Project Name: COLES INDUSTRIAL SUBD #2

SUBJECT: Project # 1007214, 08DRB-70169 Minor – Preliminary/Final Plat Approval, Lots L-4, Coles Industrial Subdivision, #2, Located on Stanford Dr. NE Between Candelaria Rd. NE and Vassar NE.

**April 16, 2008  
DRB Comments**

**RE: Lots L-4, Cole's Industrial Subdivision #2**

**PLAT OF
 LOTS L-4-A & L-4-B
 COLES INDUSTRIAL SUBDIVISION NO. 2
 SECTION 10, T. 10 N., R. 3 E., N.M.P.M.
 CITY OF ALBUQUERQUE
 BERNALILLO COUNTY, NEW MEXICO
 FEBRUARY 2008
 SHEET 2 OF 2**

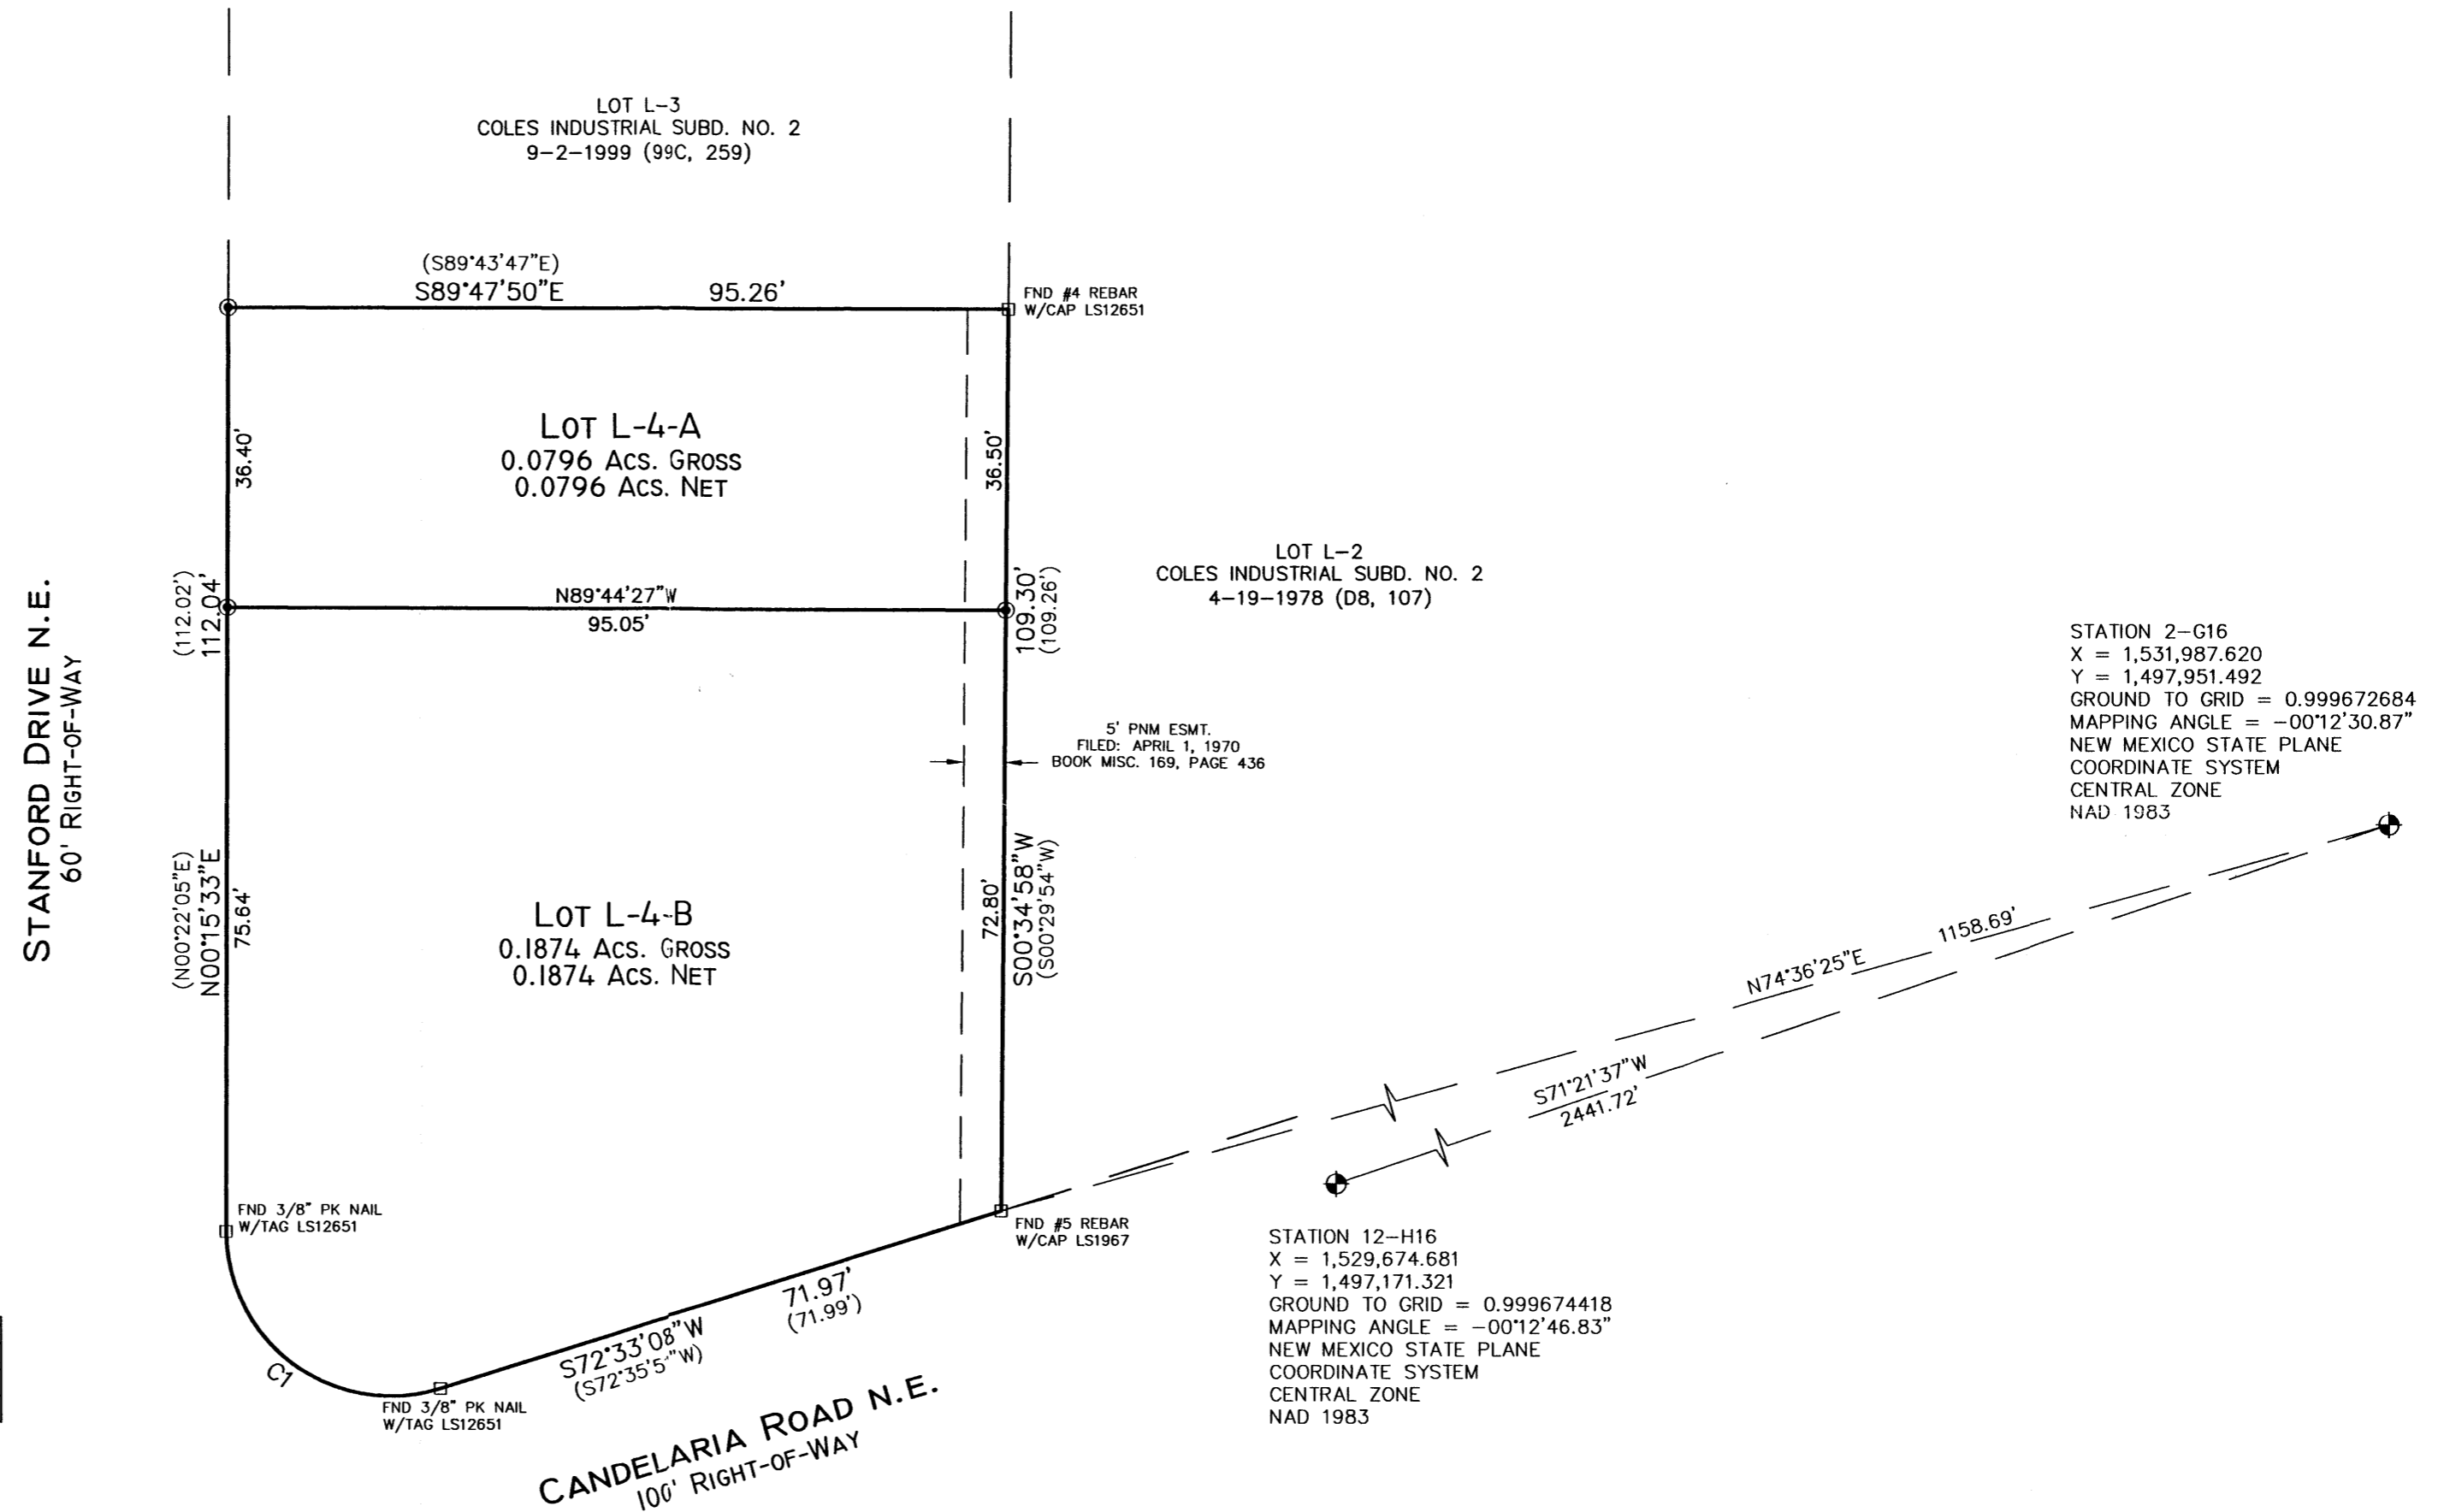
Candelaria is a principal arterial roadway in this area. Per the DPM, Table 23.3.3, the right of way at the intersection of a principal arterial and a local roadway requires a radius of 30 feet.

A site plan is needed to demonstrate adequate parking and circulation on proposed lot L-4-B (for existing building); it is unclear how existing parking layout will function without an easement on proposed Lot L-4-A, which would then render that lot un-developable.

Certification will be needed to demonstrate that the existing building meets the building code in relation to the proposed lot line.
